# **Application by Springwell Energy Farm Ltd for an order granted development consent for the Springwell Solar Farm**

## **Written Representation**

**A report prepared by North Kesteven District Council  
(ID 20054501)**

**Planning Inspectorate reference: EN01049**

TITLE:
FIGURE 3.3D
GREEN INFRASTRUCTURE PARAMETERS
SPRINGWELL WEST A

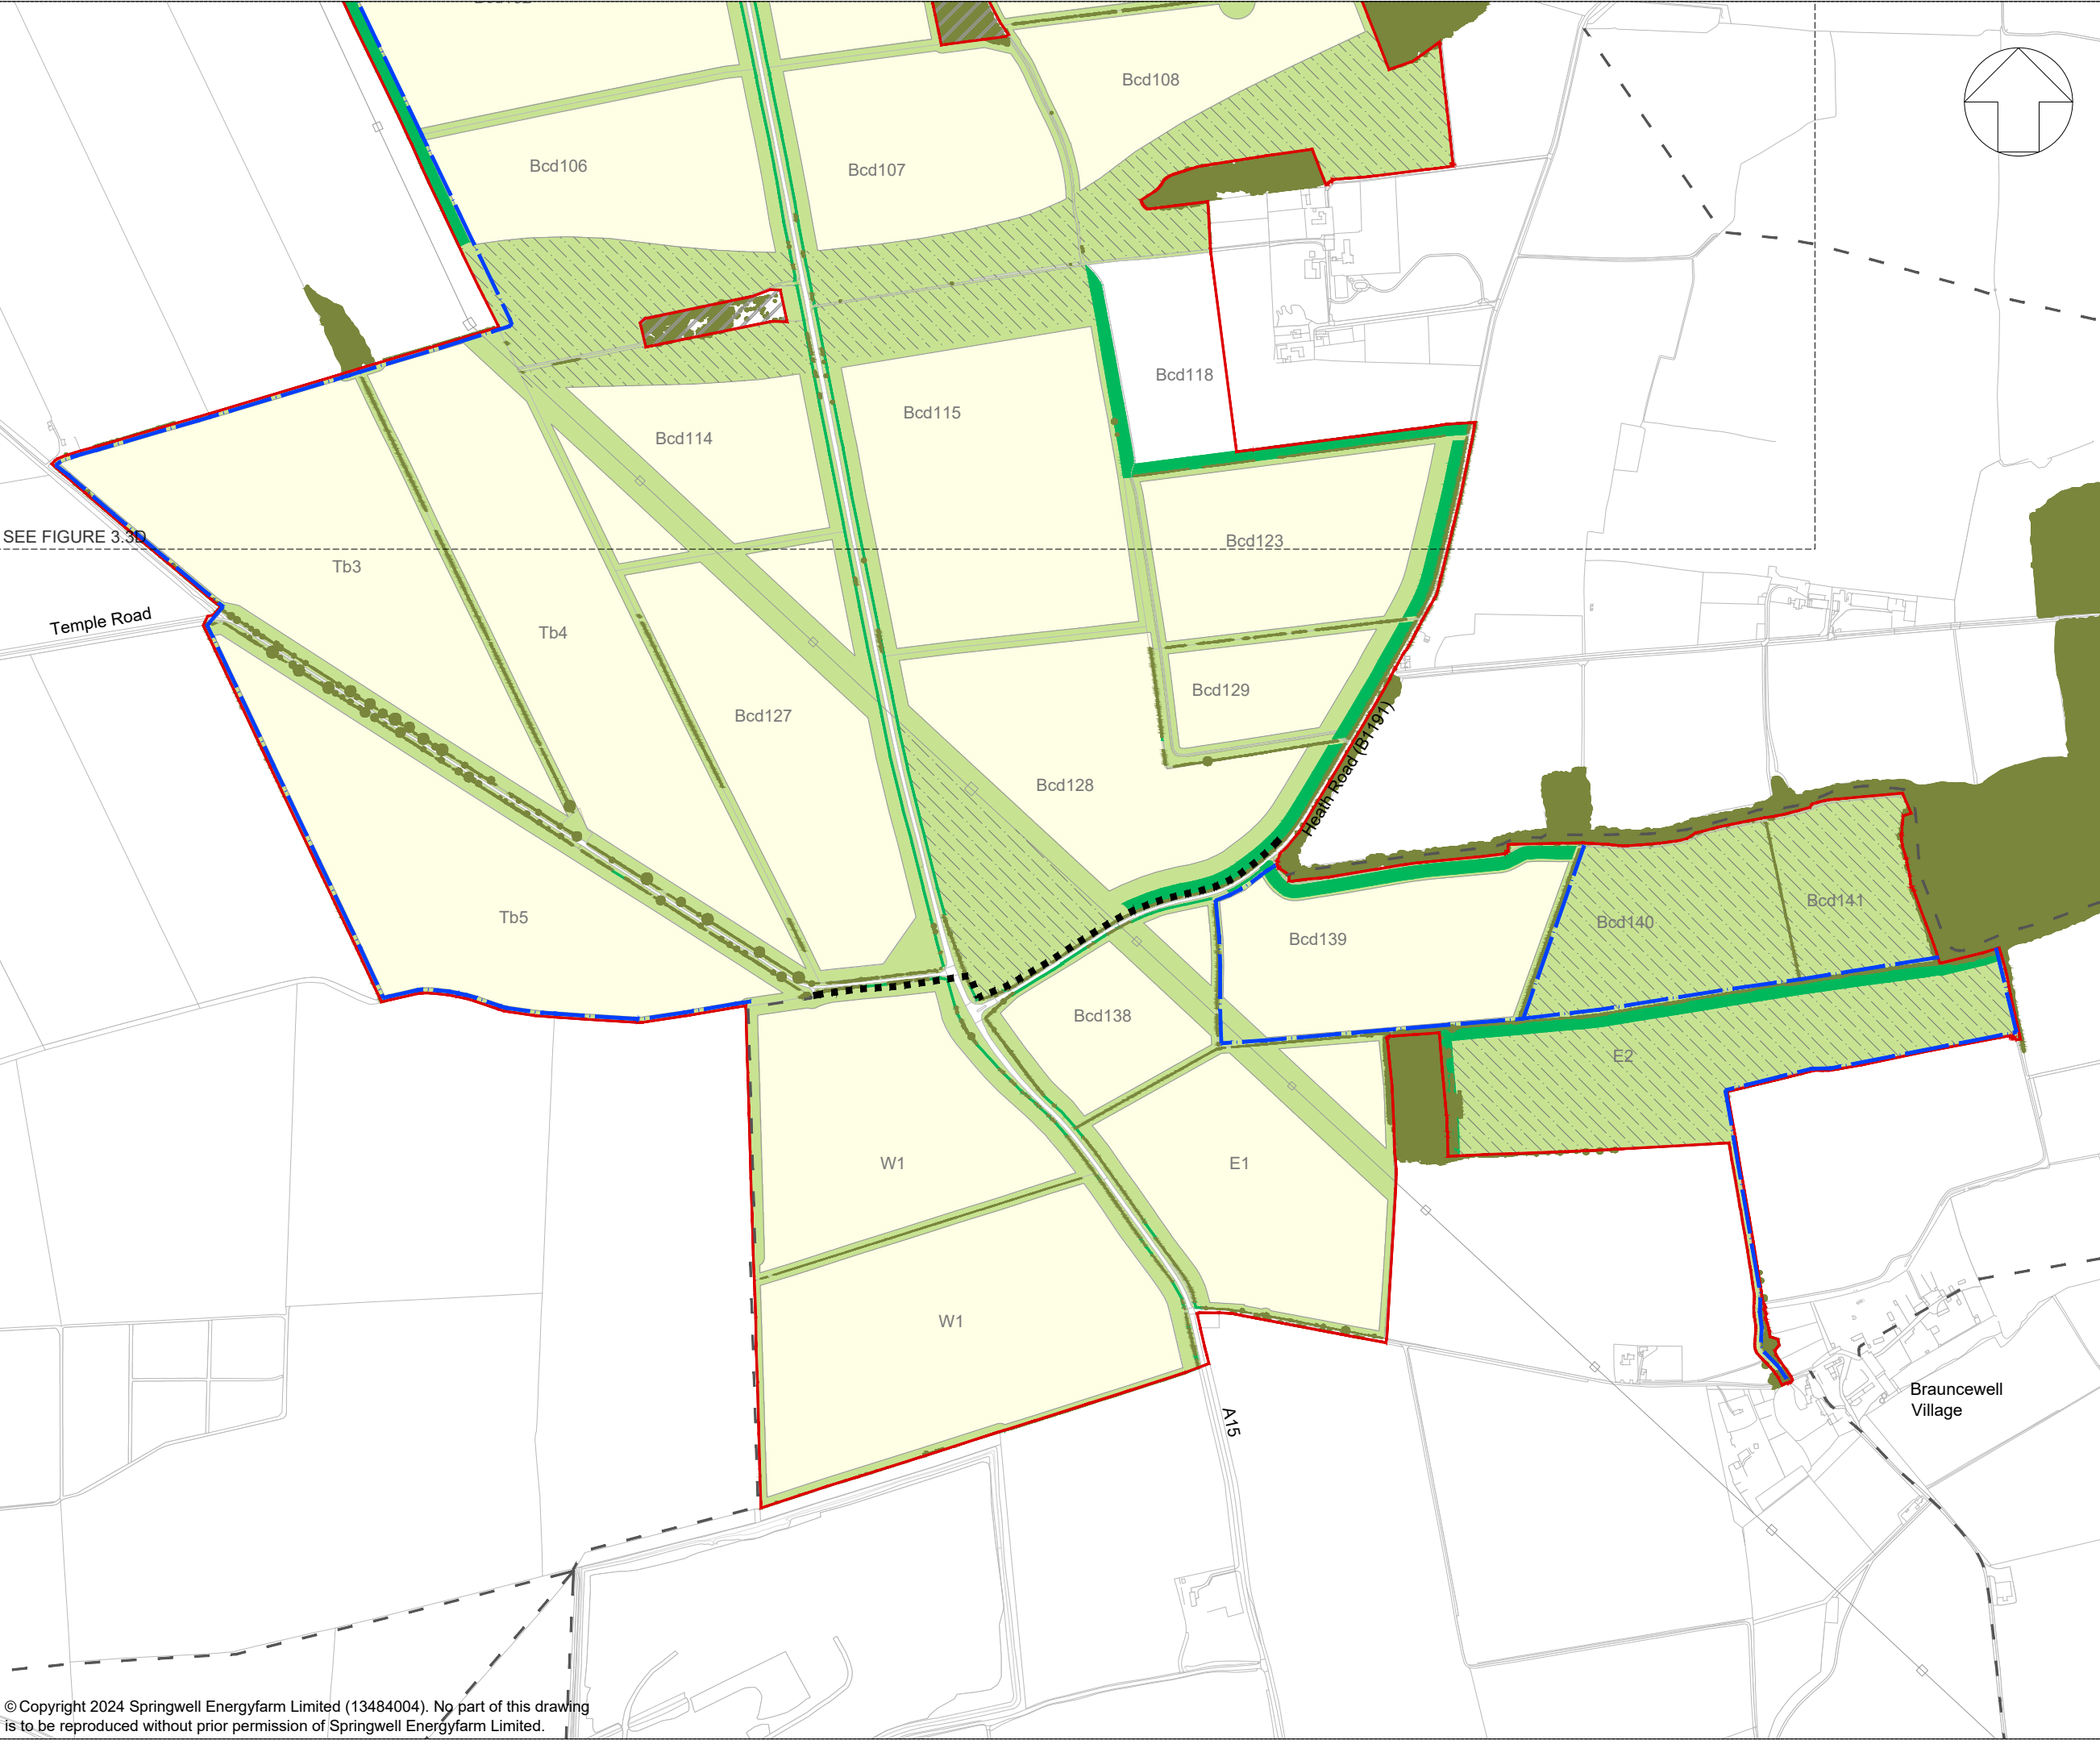
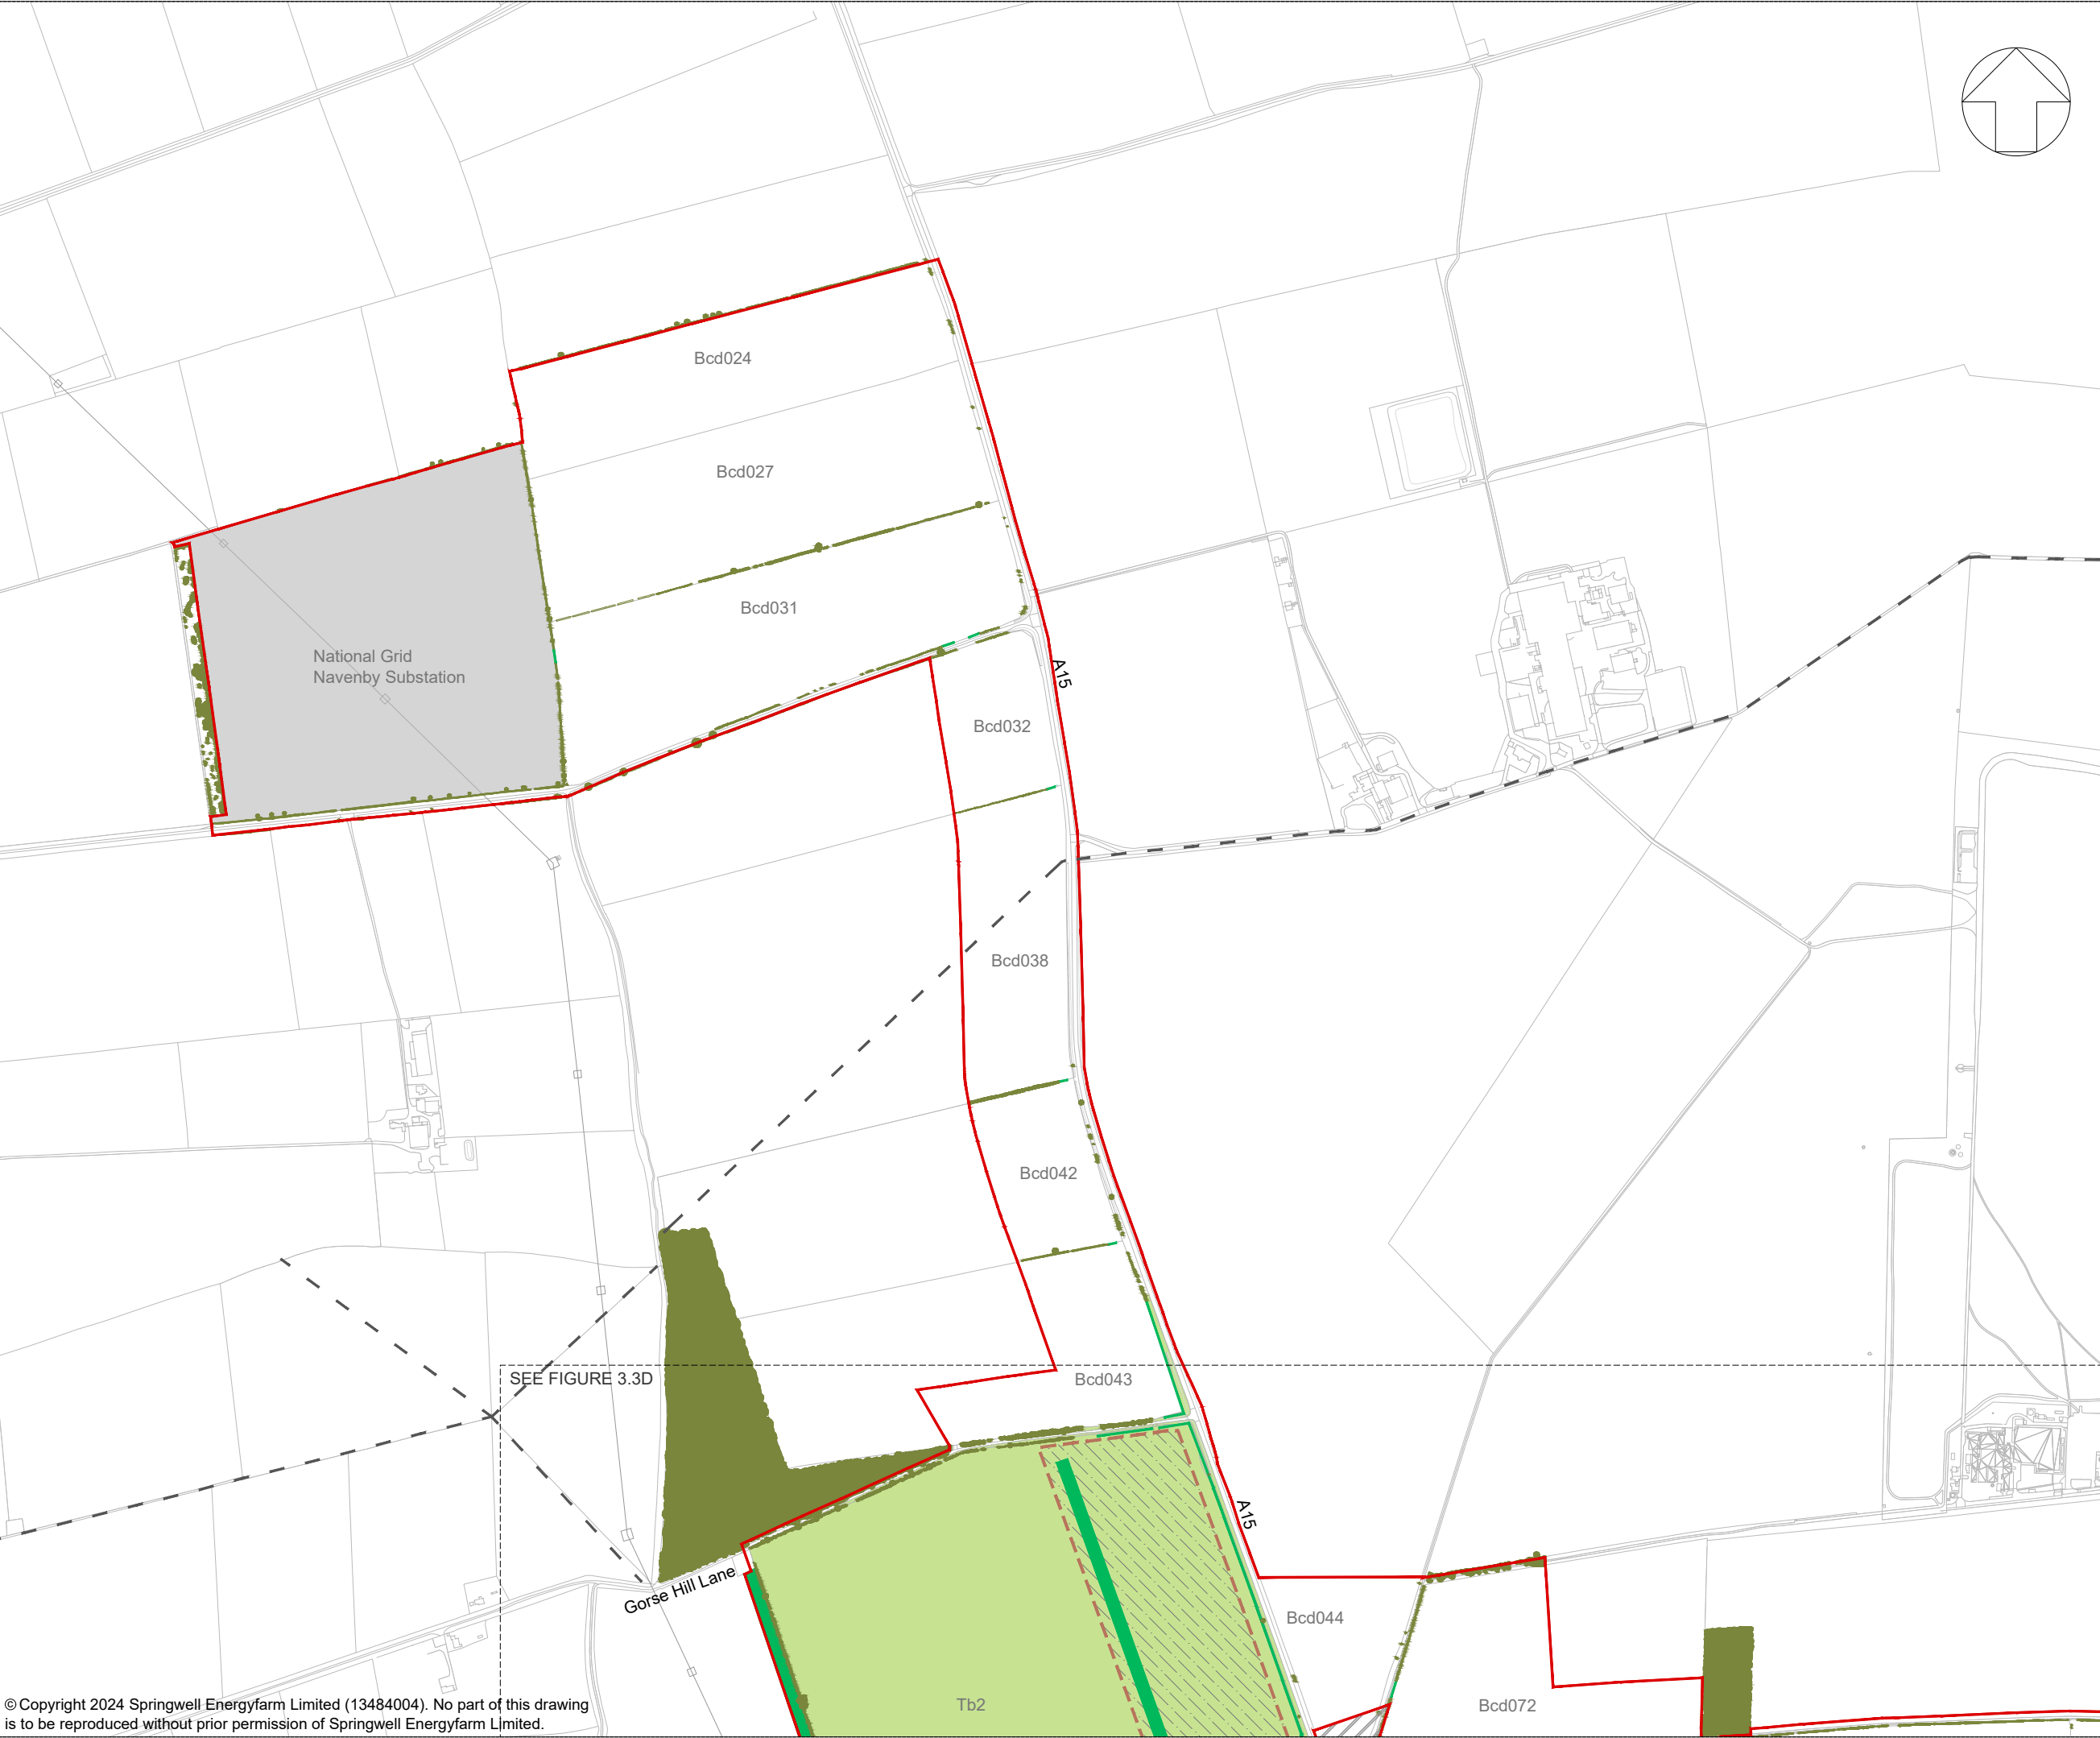
- 4.9 The BMV land to be used for temporary green infrastructure in field Tb2 (through the formation of a bund to screen the substation and BESS) and community growing area appears to be a further permanent loss of BMV agricultural land. While the land to be used as temporary green infrastructure will not be permanently sealed, it would be covered by a 3-5m bund for the duration of the solar farm. The community growing area may or may not result in a loss of BMV agricultural land. Together they would account for the further loss of up to 31ha of BMV land.
